# **Statement of Response to Pre-application Consultation Opinion**

## **Residential Development**

**Lands at Rathmullan Road, Rathmullan,  
Drogheda, Co. Meath**

**September 2019**

PLAN VIEW
 SCALE 1:750

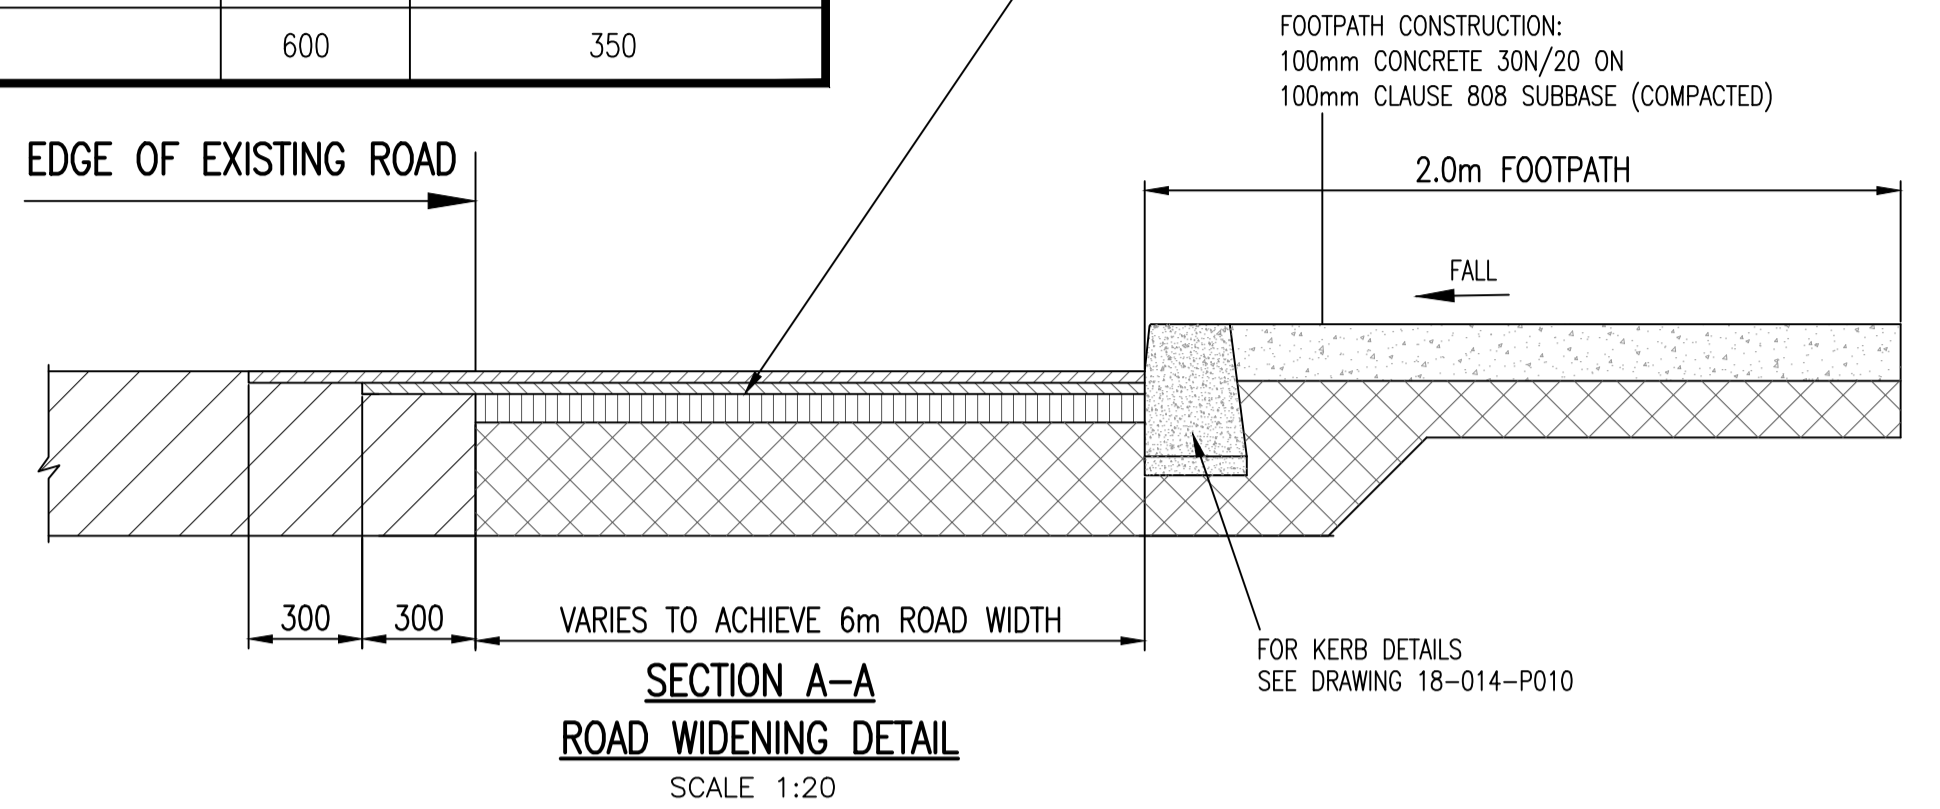
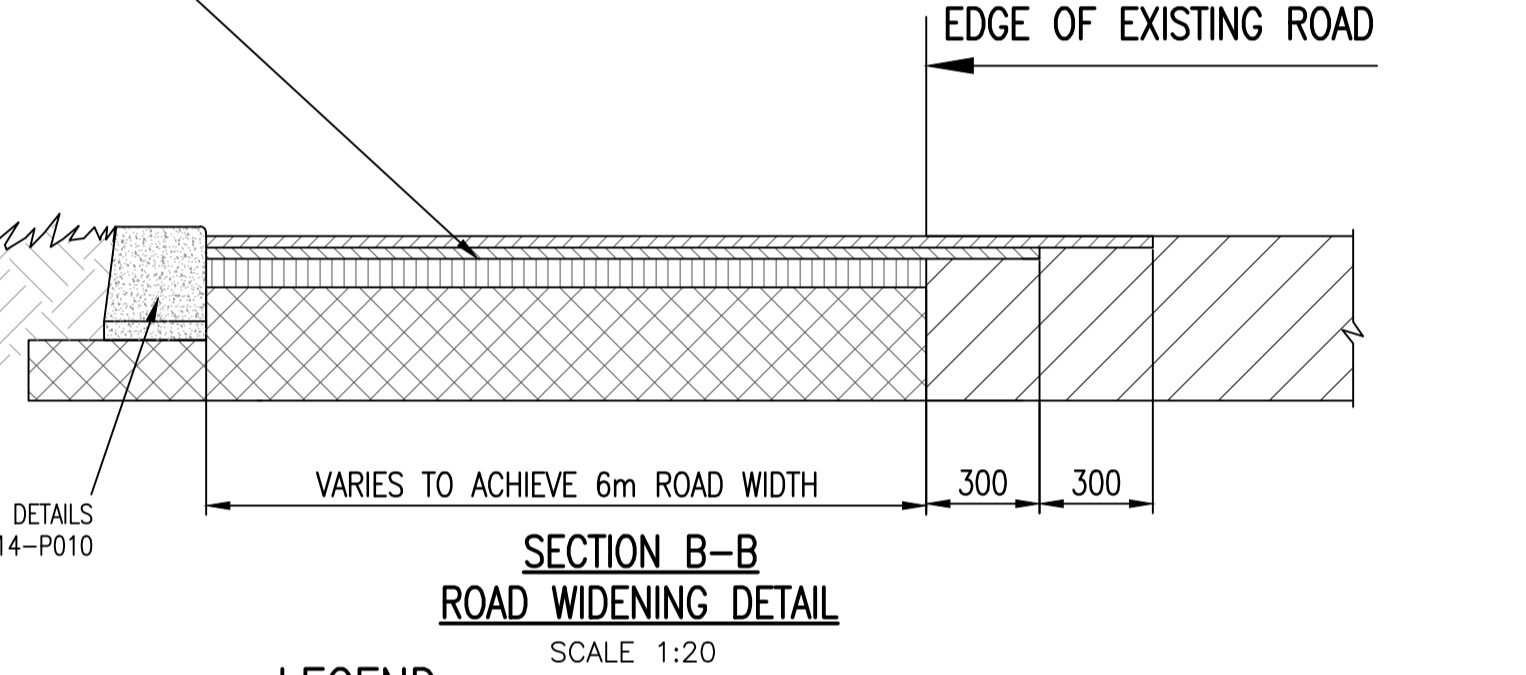
- iv. *The achievement of satisfactory pedestrian and cycle connections to the Oldbridge Road and the Boyne Rover walkway from the proposed park at the northern end of the site, with due consideration to the changes in ground levels across this area, along with related landscaping measures;*

- iv. To achieve satisfactory pedestrian and cycle connections to the Oldbridge Road and the Boyne Rover walkway from the northern end of the site, as part of the road widening works along Rathmullan Road to the north towards the River Boyne a new 2 metre footpath has been provided on the opposite side of the road. This provides a pedestrian link between the site and the River Boyne Boardwalk whilst respecting the topography and existing trees/ecological features on the site. Please see Section A-A on Drawing No. P012, prepared by Waterman Moylan Consulting Engineers, for specific details.
